Preliminary Acceptance Punchlist
El Paso County – Department of Public Works - Stormwater Section

Project Name:	Widefield Park & Rec Improvements
EDARP Filing Number(s):	PPR2213, CON2261
ESQCP Number:	ESQ2250
Attendees:	DPW SW: Natasha Grimaldo, Ben Jones, and Mikayla Hartford DPW Development Services: David Parkerson and Brad Walters Developer: Justin Harrod
Date of Walk-Thru:	08-22-2023
Walk-Thru Number:	1 st

C7.5

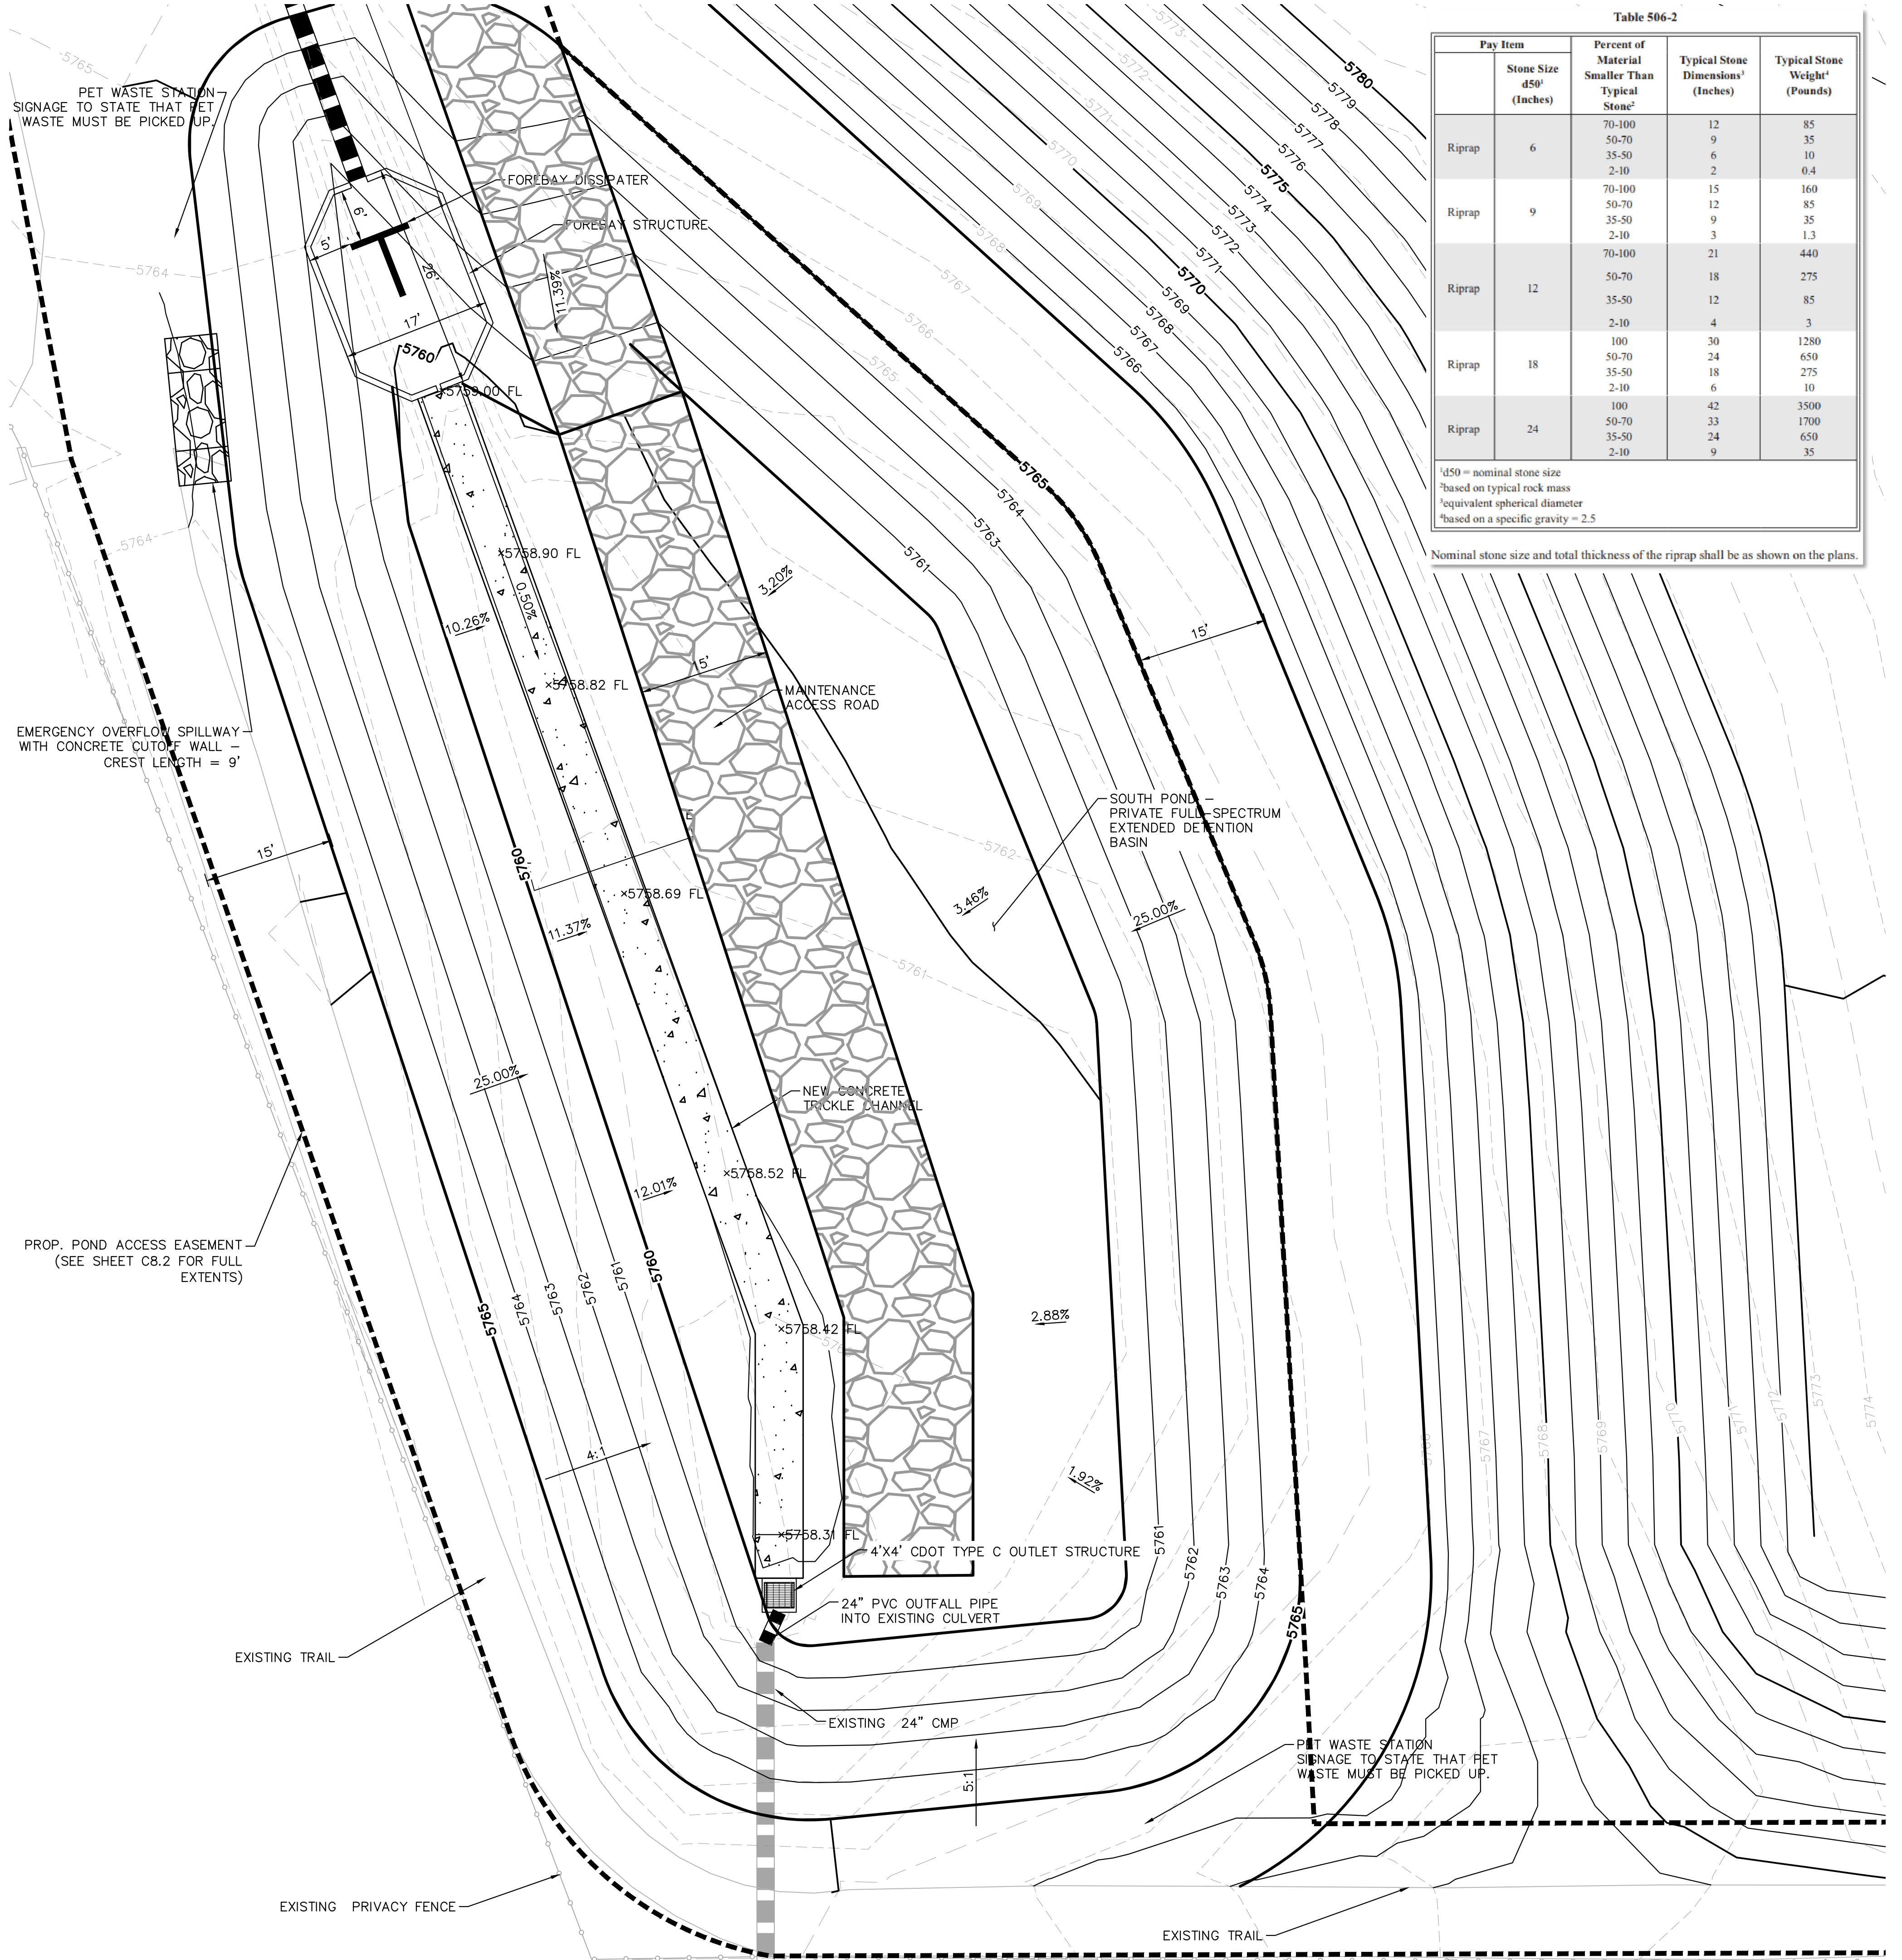
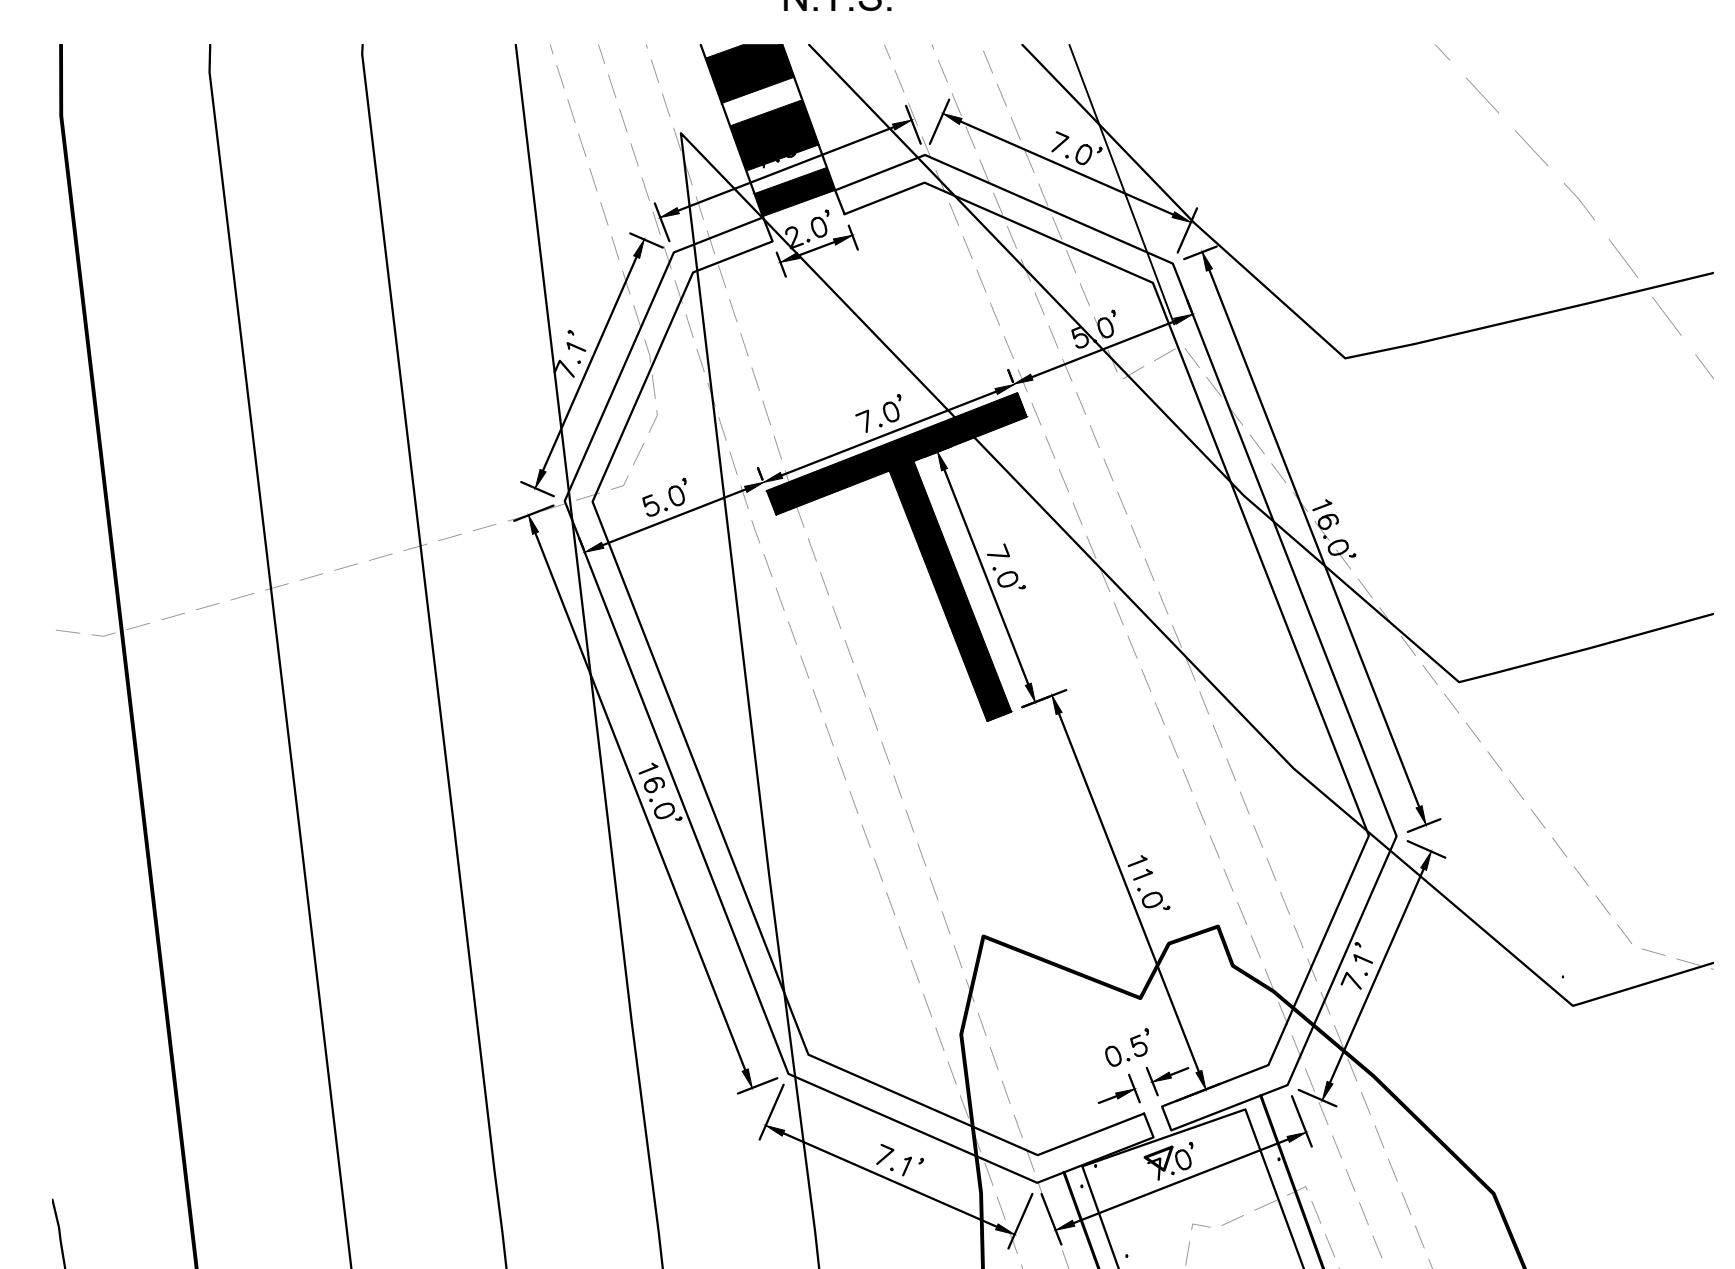
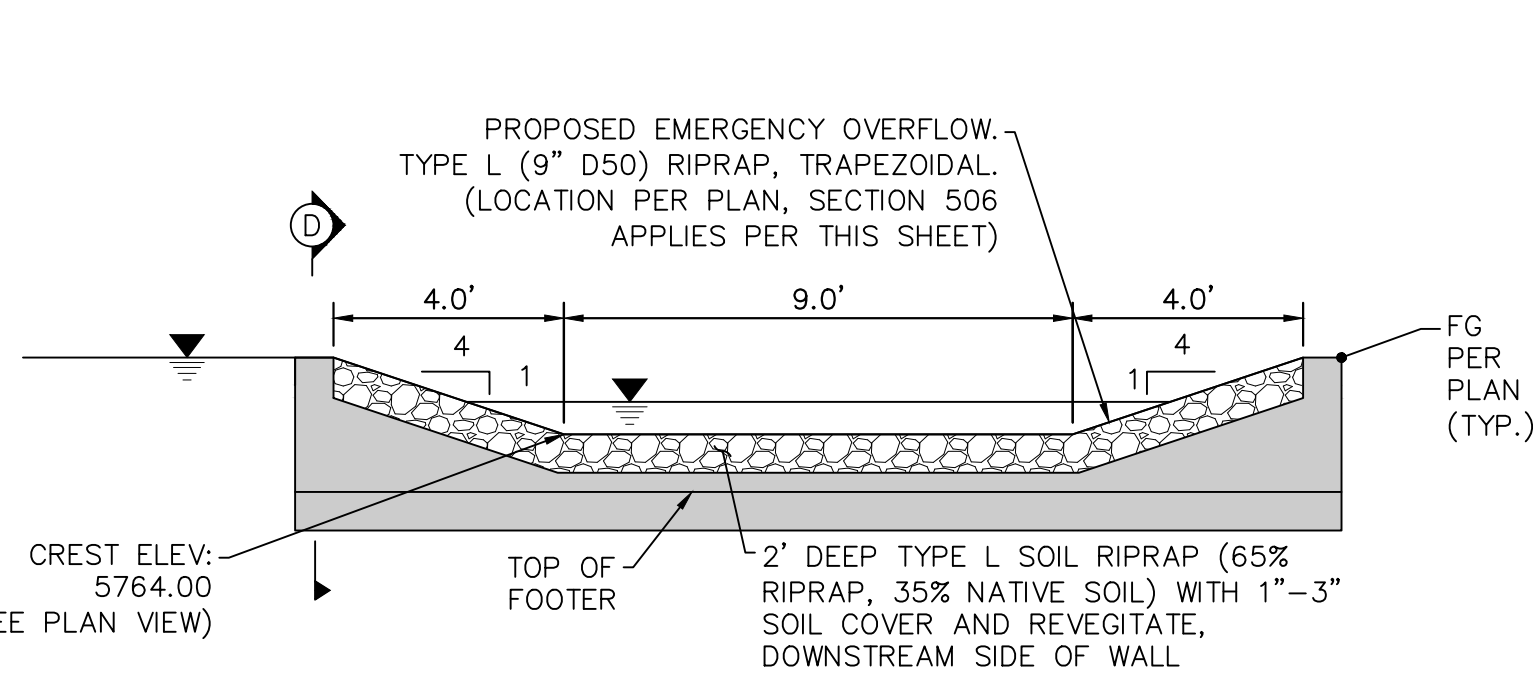
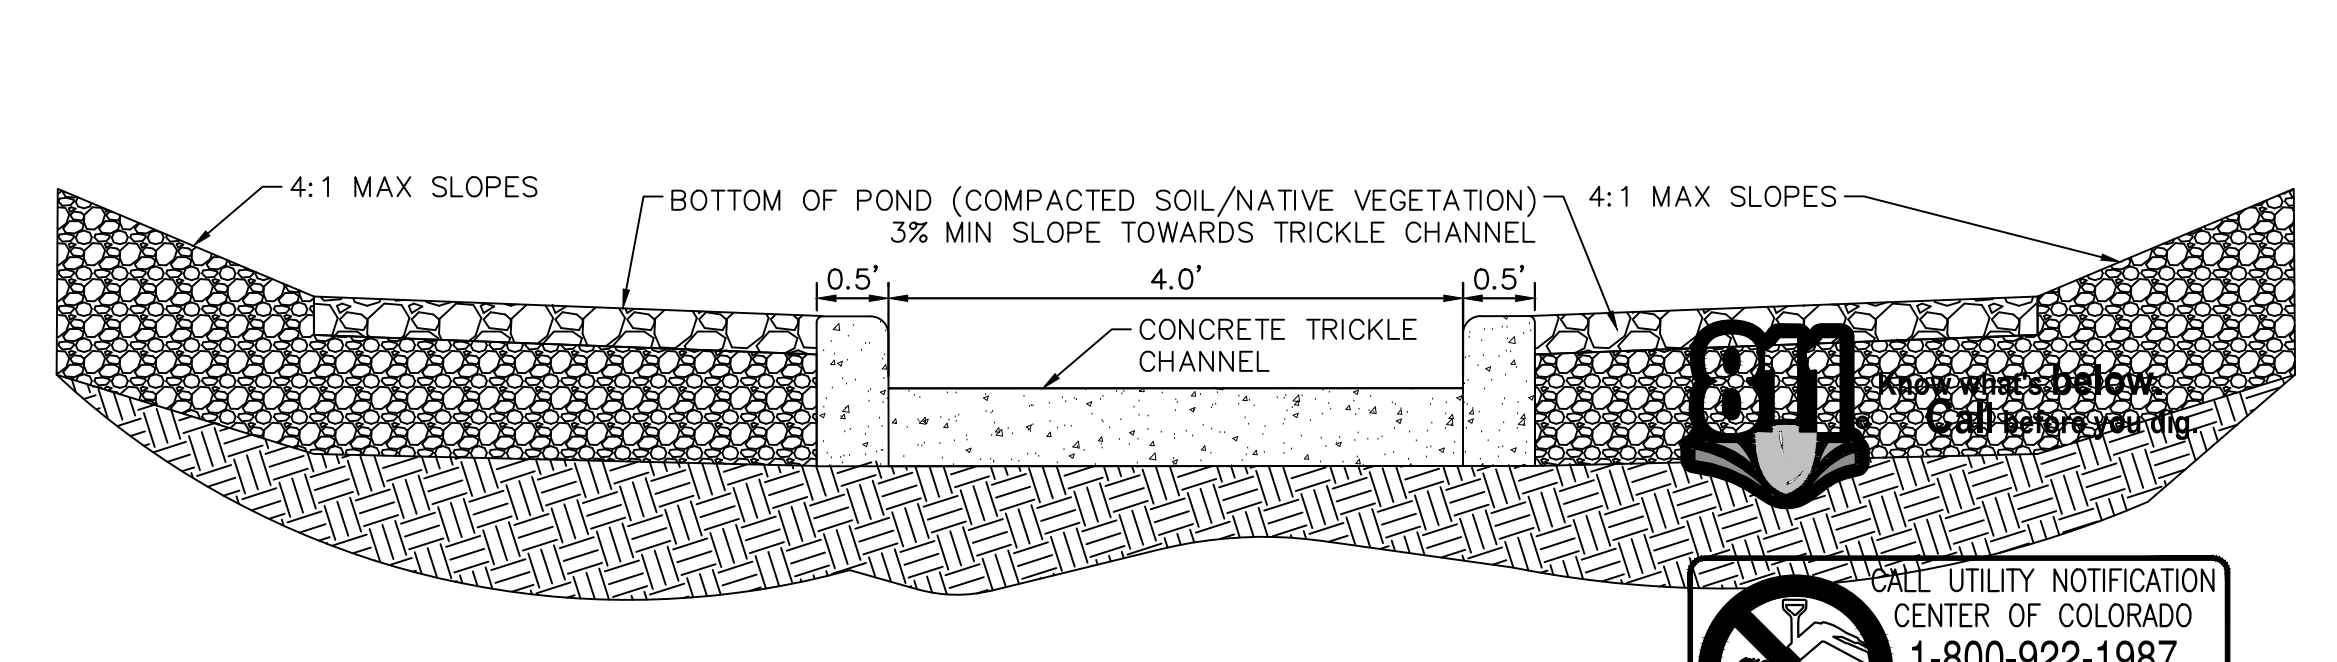
- Confirm installation of the emergency overflow spillway. Spillway should be trapezoidal, 21' Weir width, with 4:1 slopes of 6' on either side. Reference sheet C7.5 of the Construction Documents.

- Fine grade rill erosion around the forebay and stabilize.
- Outlet structure: Replace trash screen with No. 93 Johnson Vee Wire or Equivalent. Reference sheet C7.5 of the Construction Documents.

- Outlet structure: Install bolts or locks on grate per the approved plans. Reference sheet C7.5 of the Construction Documents.
- Outlet structure: Install concrete cross-member or equivalent between the trash screen and orifice plate gap. Reference sheet C7.5 of the Construction Documents.

Photo 9: Pond: Confirm installation of the emergency overflow spillway. Spillway should be trapezoidal, 21' Weir width, with 4:1 slopes of 6' on either side. Reference sheet C7.5 of the Construction Documents.

Photo 12: Pond: Replace trash screen with No. 93 Johnson Vee Wire or Equivalent. Reference sheet C7.5 of the Construction Documents.

Photo 13: Pond: Install bolts or locks on grate per the approved plans. Reference sheet C7.5 of the Construction Documents.

Photo 14: Pond: Install bolts or locks on grate per the approved plans. Reference sheet C7.5 of the Construction Documents.

Photo 15: Pond: Install concrete cross-member or equivalent between the trash screen and orifice plate gap. Documents. Reference sheet C7.5 of the Construction Documents.
